Planning application no: 2021/94552

Land at, Barnsley Road, Denby Dale, Huddersfield HD8 8TS.

Erection of 53 dwellings and associated works

Comments for inclusion in the public consultation relating to the above planning application.

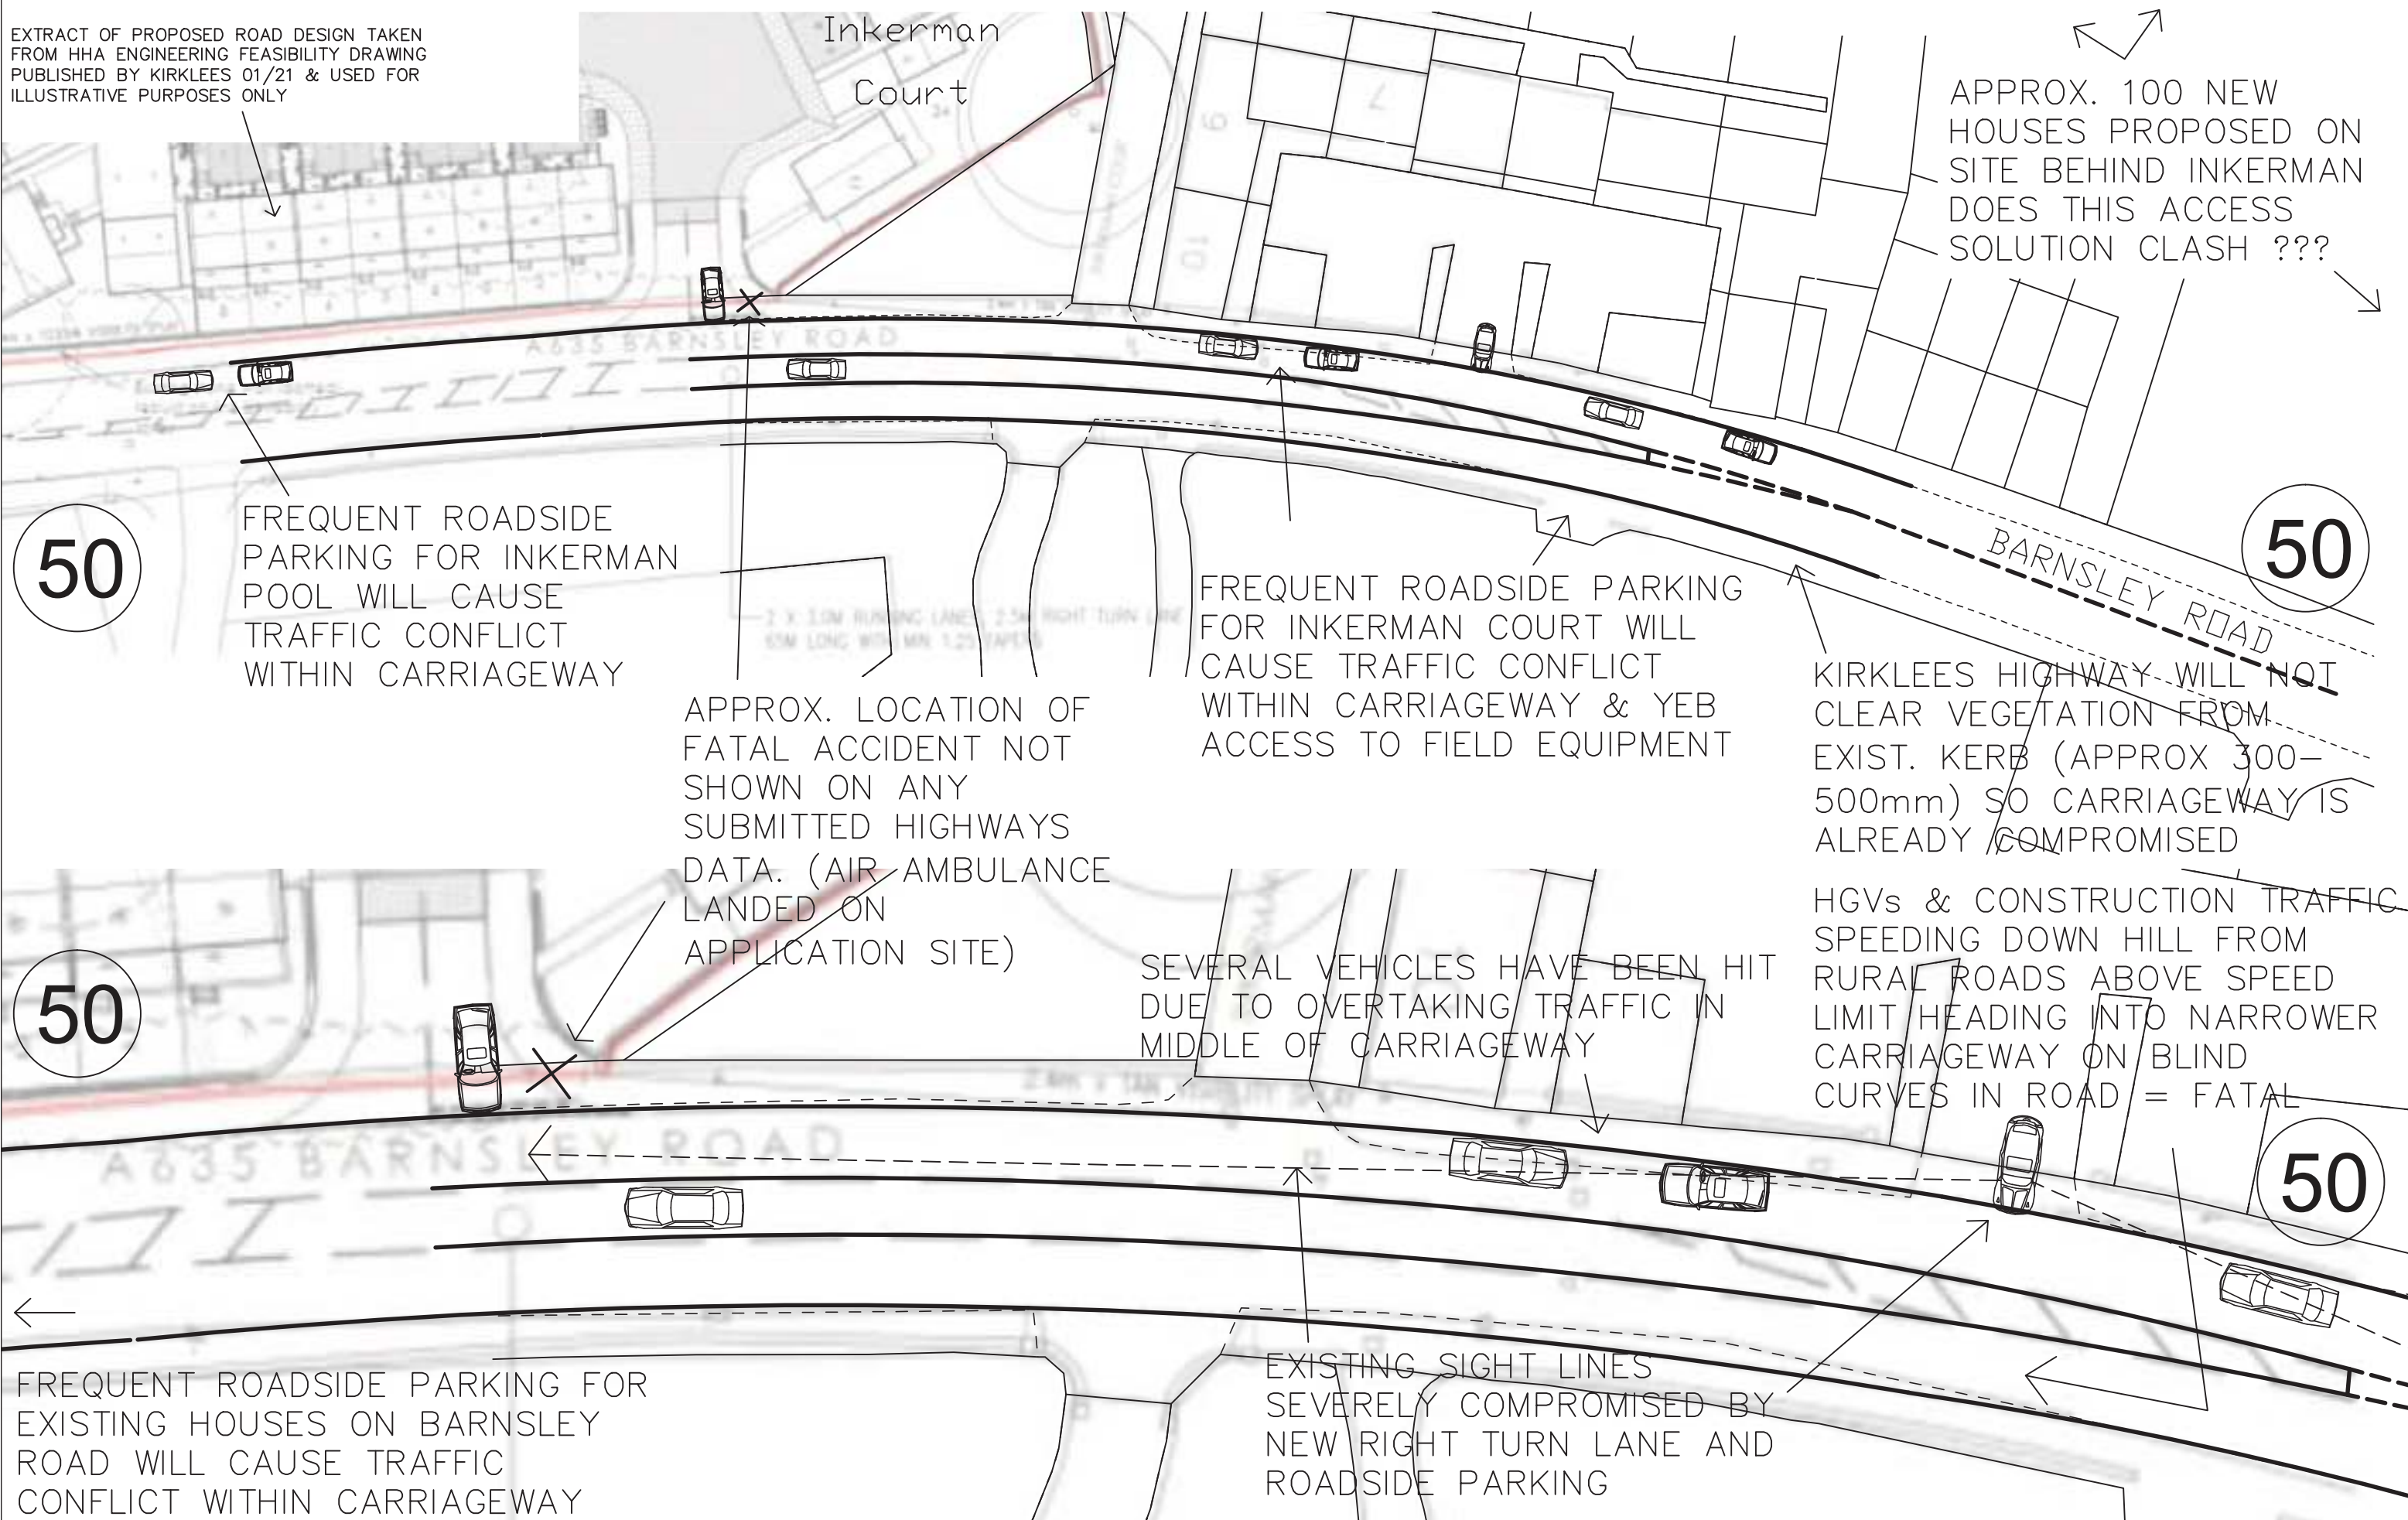
The sightline from the site access road looking eastward up Barnsley Road, marked as a 120m x 2.4m visibility splay (see Andrew Mossley Associates Proposed Site Access plan: ref AMA/21154/SK002 id908368) utilises the neighbouring field on the eastern boundary. This is not reflected on the red line boundary on the site location plan and there is no commentary as to how this sightline can be guaranteed in future.

Another notable point is that the sight line looking eastward as well as extending beyond the site boundary, also runs through the front gardens of four proposed dwellings. This is not good practice as it is probable that the sight line will not be retained by these residents. Over time trees and shrubs will be planted and possibly boundary fences and garden sheds erected. The garden areas to these units should be set back behind the visibility splay.

Furthermore, the visibility splays indicated assume a reduction in traffic speeds and speed limit, which cannot be guaranteed. The visibility splay should satisfy normal design criteria based on current traffic speeds and speed limits (rather than relying on reductions), which it does not.

## Appendix 10: Retaining structures

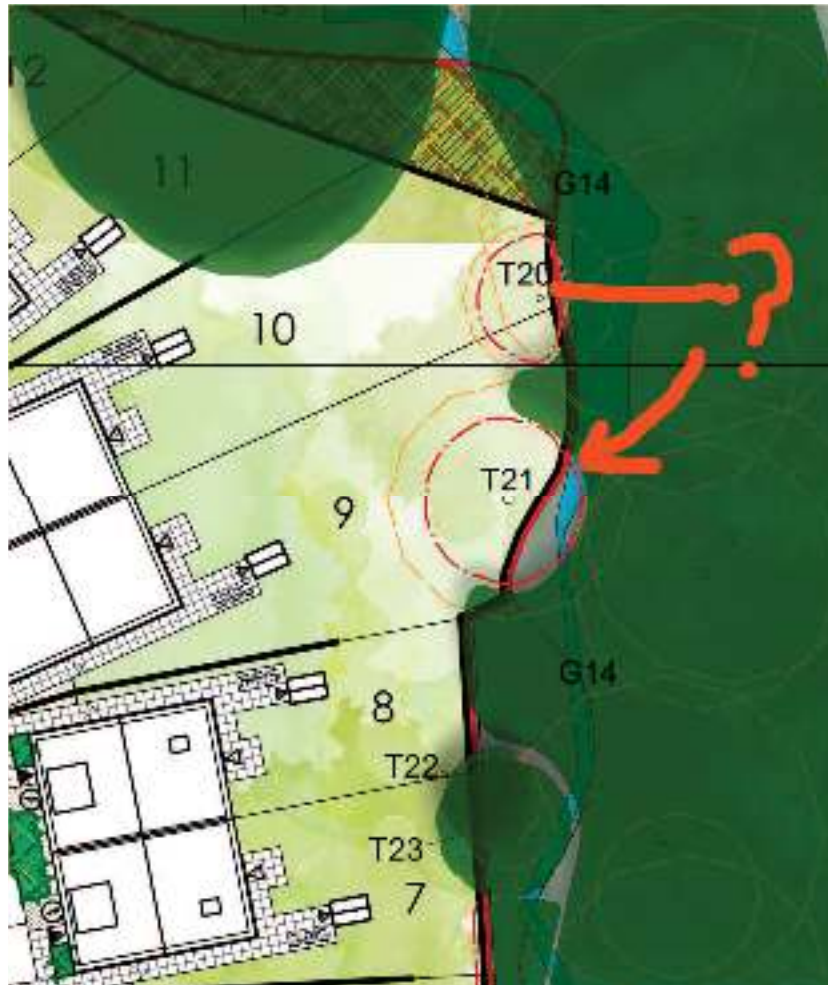
Indeed when looking at the 250 Engineering Feasibility drawing, retaining structures are shown and there is no detail of these included within the application so we must insist that these are provided as a matter of urgency to determine the severity of overlooking on the Inkerman Way properties. See Appendix 10.

## Appendix 12: North Boundary retaining structure and materials issue

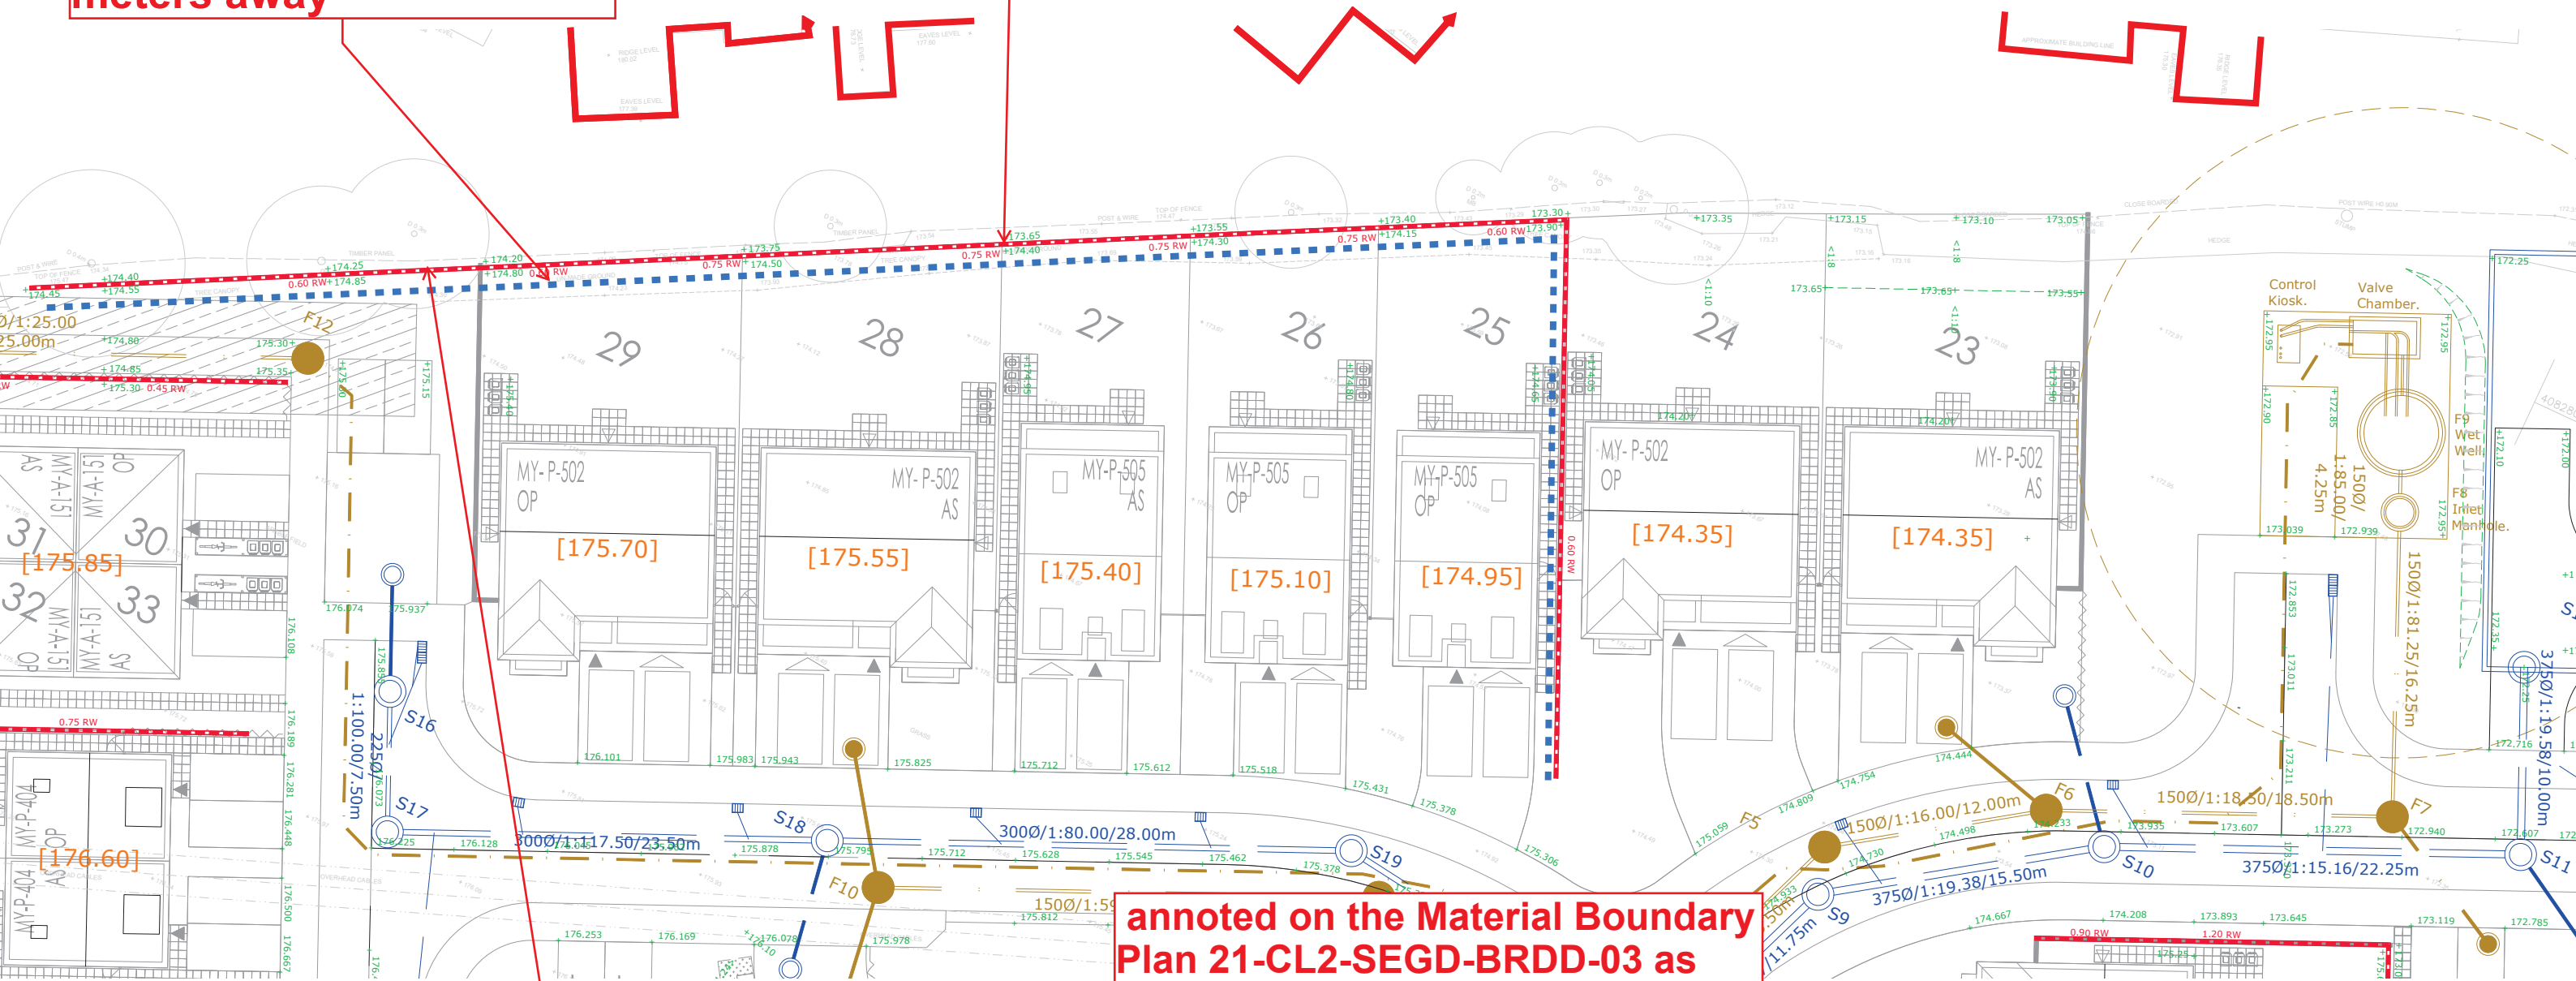
- b) Datums relating to the height of the proposed boundary fencing around the site (See Strata Material, Boundary & Surface Plan (ref 21-CL2-SEGD-BRDD-03 id908375) are missing and so the overlook impact cannot be assessed. There are also very few proposed levels indicated on the drawings provided and the application should not be determined without this critical information. We insist that this information is provided as a matter of urgency before the public consultation period ends. Specifically, finished floor levels at both ground, first and second floors are requested along with key levels to the boundaries as preliminary checks reveal the potential need for retaining structures and these are not indicated on the proposed layouts. See Appendix 12.
